P/167/21 (RES) Approval of reserved matters (appearance, layout, landscaping and scale) following outline planning permission P/140/16/OUT for the erection of 375no. dwellings, together with public open space, play space, drainage, parking and associated infrastructure, landscape, ancillary and site preparation works, with access off Pagham Road (alternative to P/153/21/RES). This site may affect a Public Right of Way.

Land south of Summer Lane and West of Pagham Road, Pagham

The SOS **objects** to this planning application for three reasons:

PROJECT TITLE: Land West of Pagham Road, Pagham	
PROJECT NUMBER: DD538	PLOT DATE: 18.11.21
DRAWING SCALE: 1:500	APPROVED BY: PD
PAPER SIZE: A1	DRAWN BY: SL
DRAWING TITLE: Landscape General Arrangement Plan 4 of 5

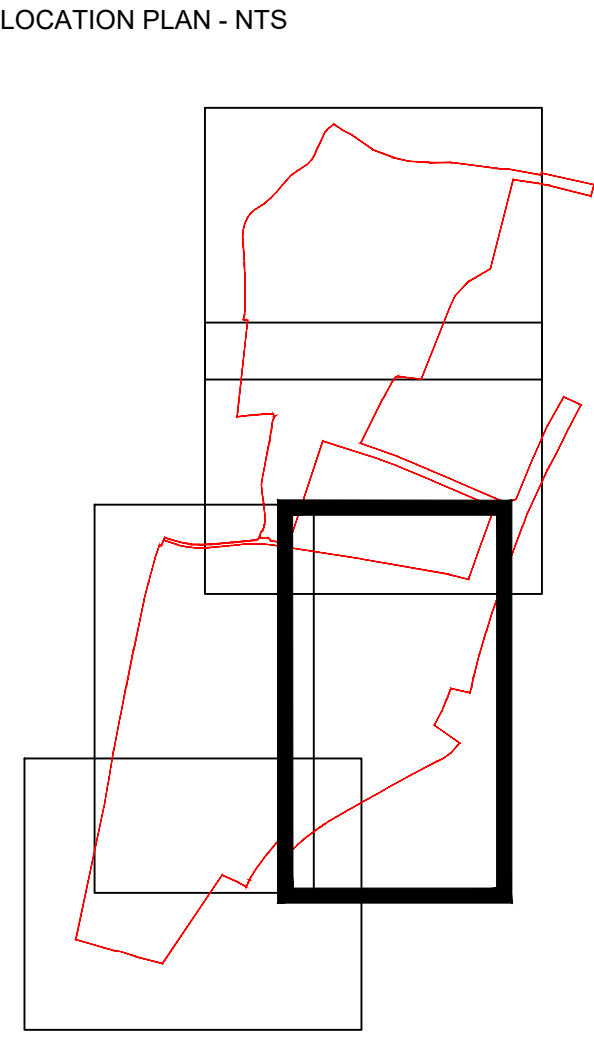
3. We also object because we believe that dogs could freely access the land beyond the western boundary. This is because the proposed narrow strip of "wetland" planting within the SUDs area along the western boundary shown on Landscape Sheets 3 and 5 would only deter dogs crossing the western boundary when the SUDs is flooded to some depth, which presumably will only be on a very limited number of days each year. Therefore, it appears that dogs would be able to run onto these fields across the dry SUDS depression most of the time. There is also a bridge crossing the SUDS which gives direct access into this field.

Since this SUDS is not part of any waterway we question how viable it would be for any wetland planting in it to survive, especially over the summer.
